From: Michael Barker [REDACTED]
Sent: 18 April 2017 10:48
To: David Easton
Subject: RE: A/45/17/CLP - 15 The Walkway, Angmering

From: David Easton [REDACTED]
Sent: 12 April 2017 16:50
To: [REDACTED]
Subject: A/45/17/CLP - 15 The Walkway, Angmering

Having looked at the certificate of lawfulness application which has been submitted under reference A/45/17/CLP it appears that the proposed railings would not accord with the limitations of Schedule 2, Part 2, Class A of The Town and Country Planning (General Permitted Development) Order 2015 (as amended) as they would be situated adjacent to the highway and exceed 1m in height.

PROPOSED FRONT ELEVATION

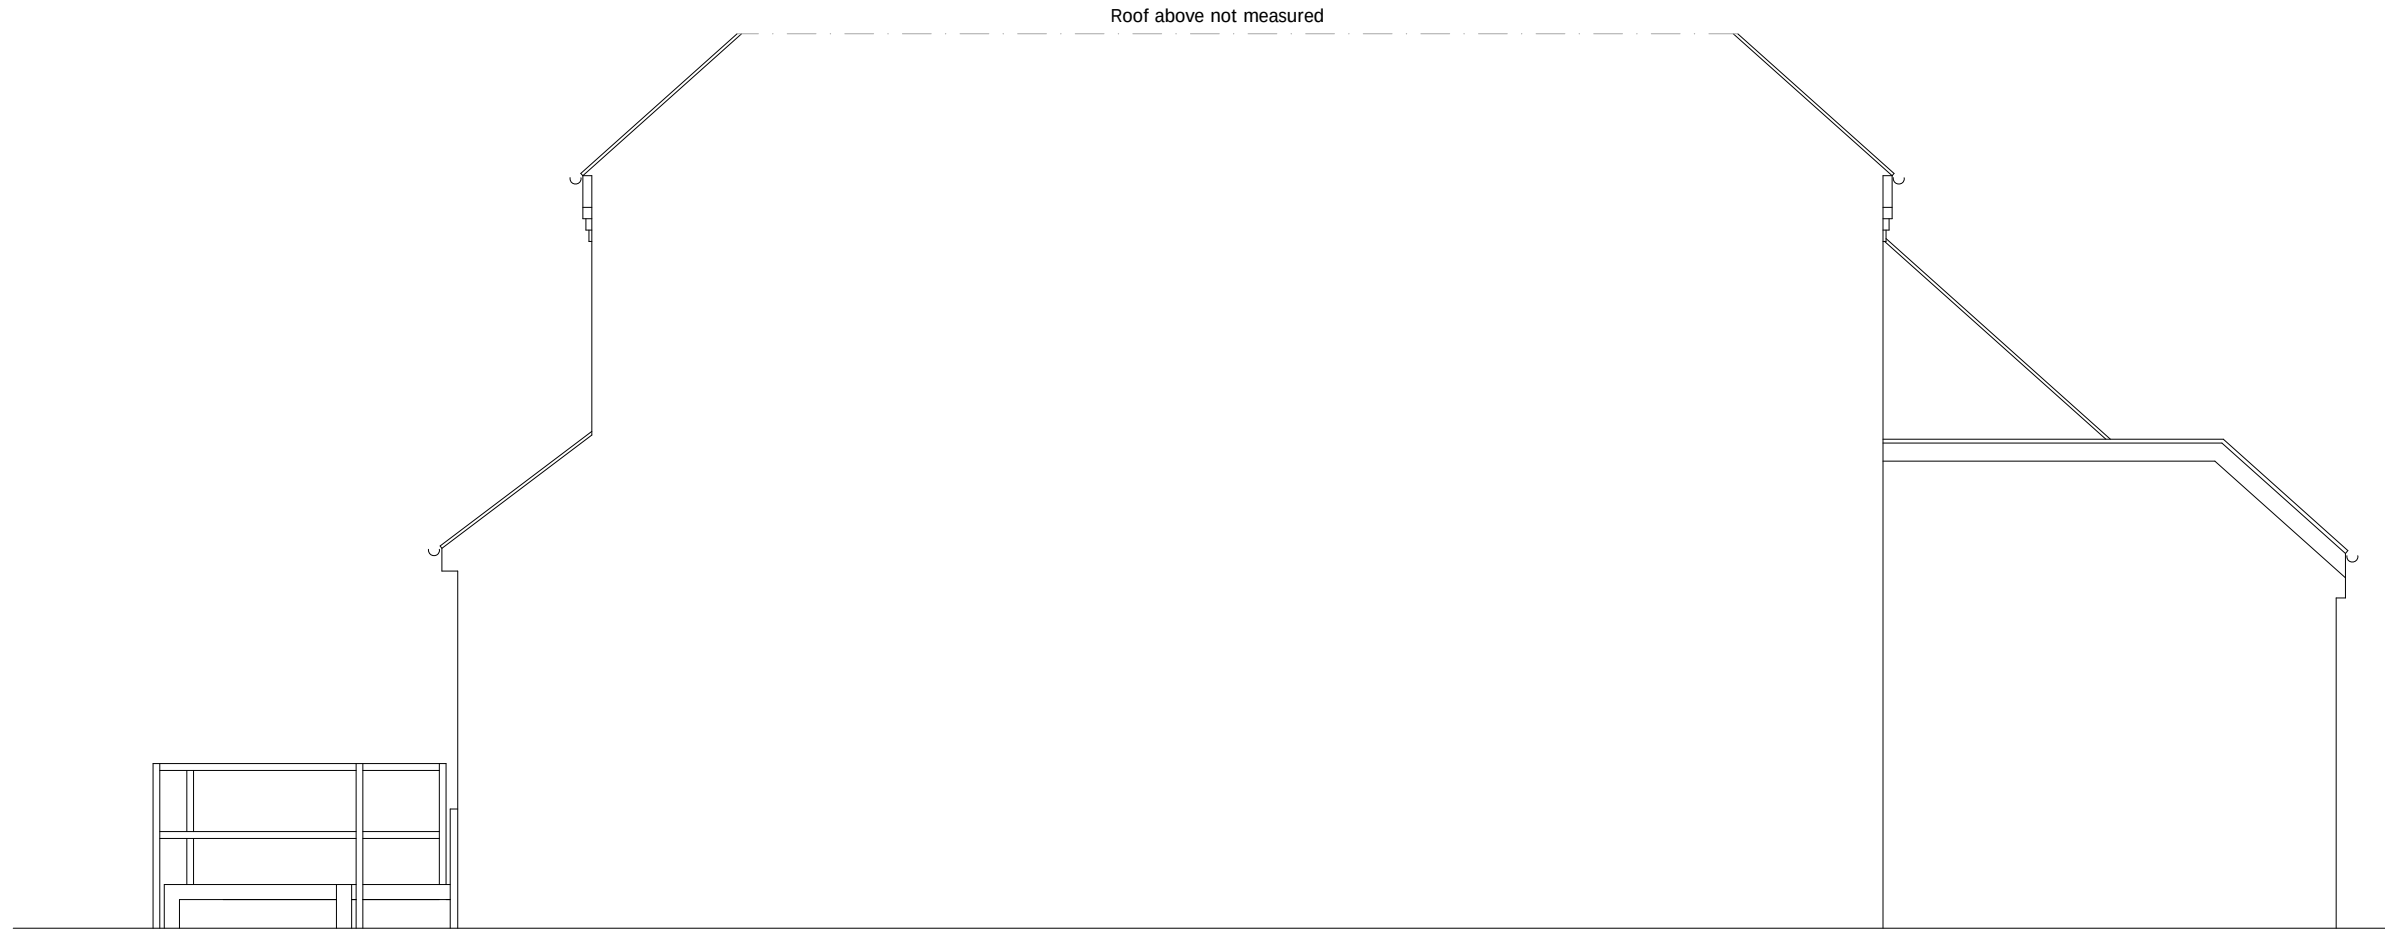
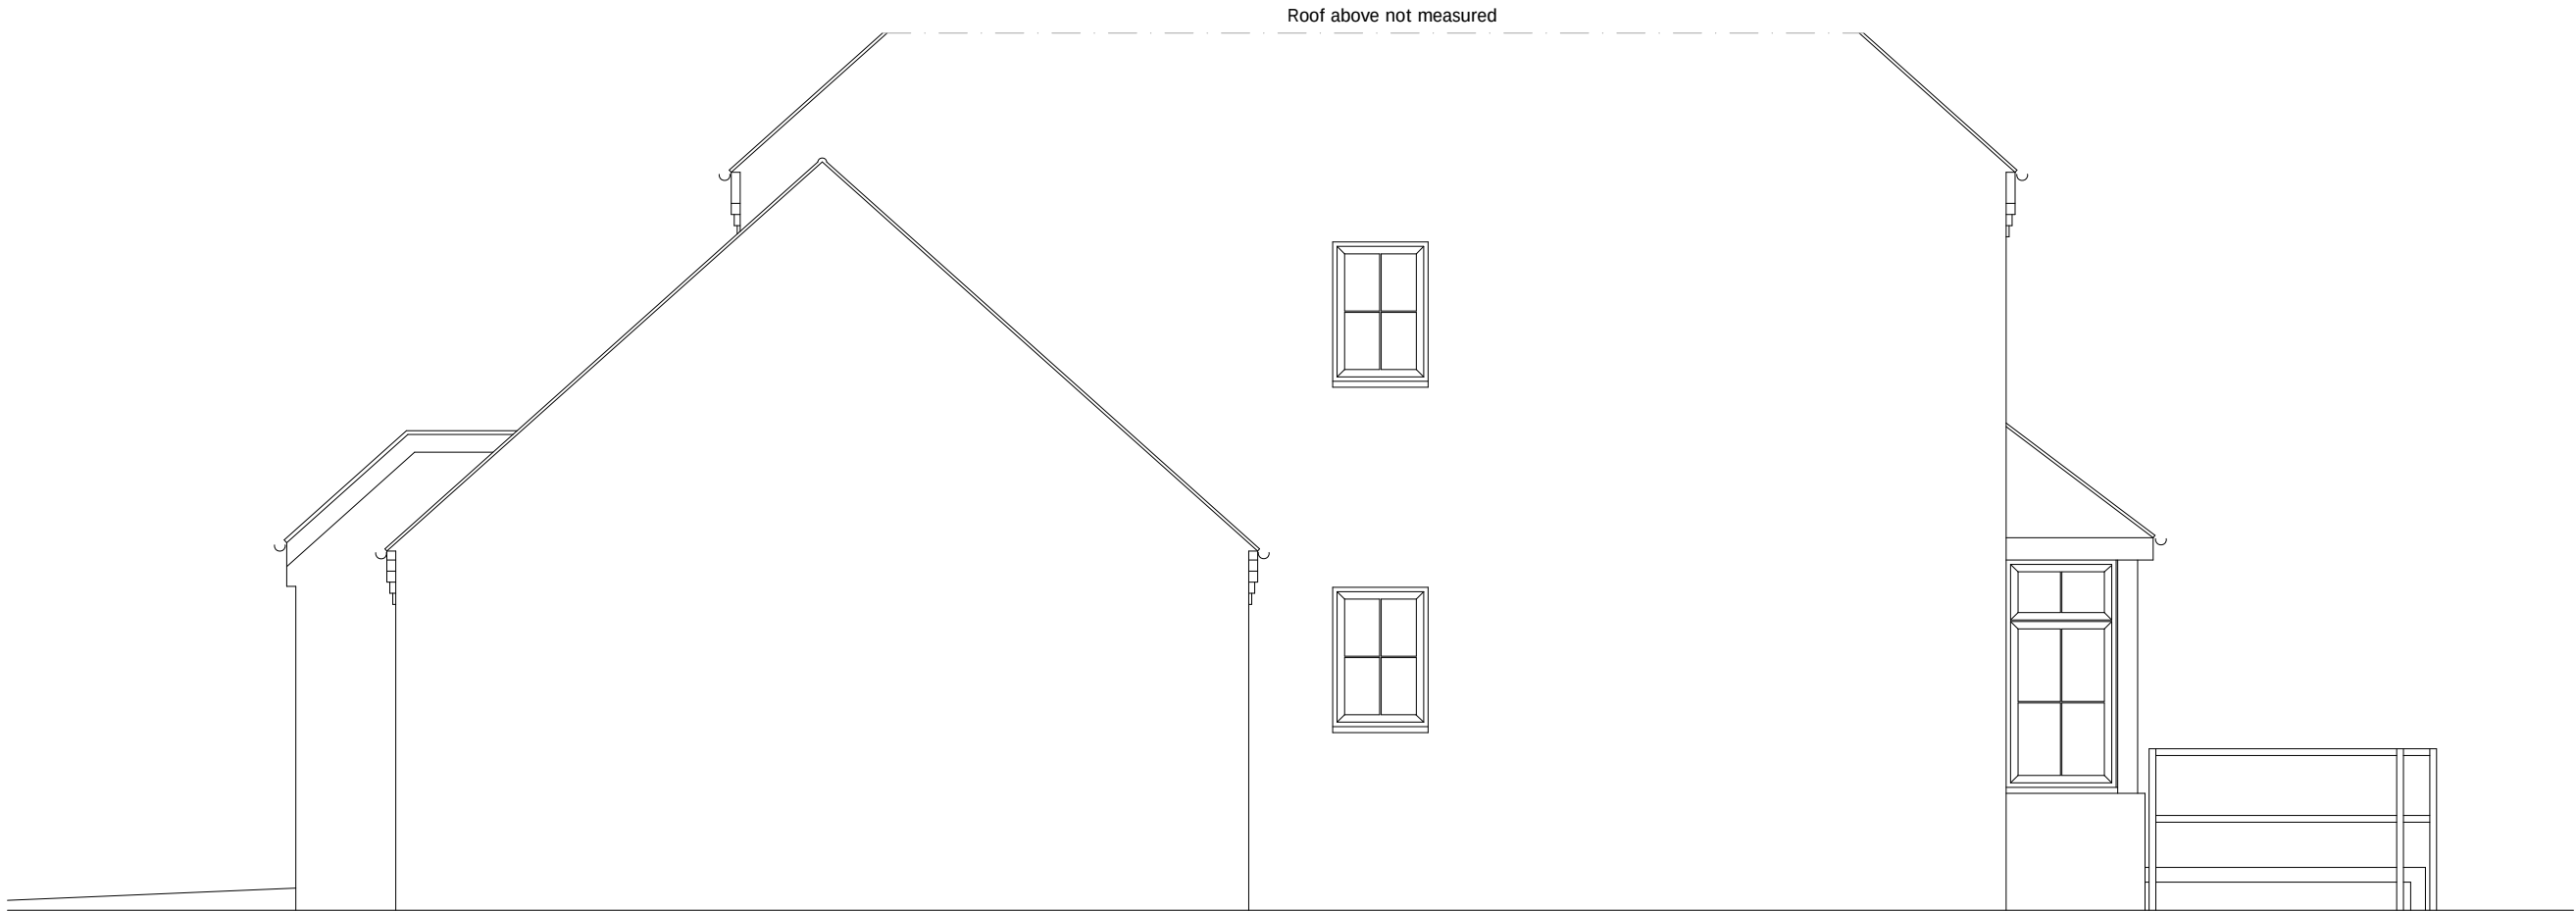
It should also be highlighted that the new access ramp shown forward of the primary elevation by virtue of its location and attachment to the dwelling house would not benefit from permitted development rights under Schedule 2, Part 1, Class A of The Town and Country Planning (General Permitted Development) Order 2015 (as amended). Thus the railings must be reduced in height and the access ramp will need to be removed from the application in order for the certificate of lawfulness to be granted. Failure to amend the application as set out above will prevent the lawful development certificate from being granted.

Please find attached the amended plans as requested. I have omitted the front access from this application and submitted a separate planning application for the front access only. Please also note that the roof construction has changed to a flat roof.
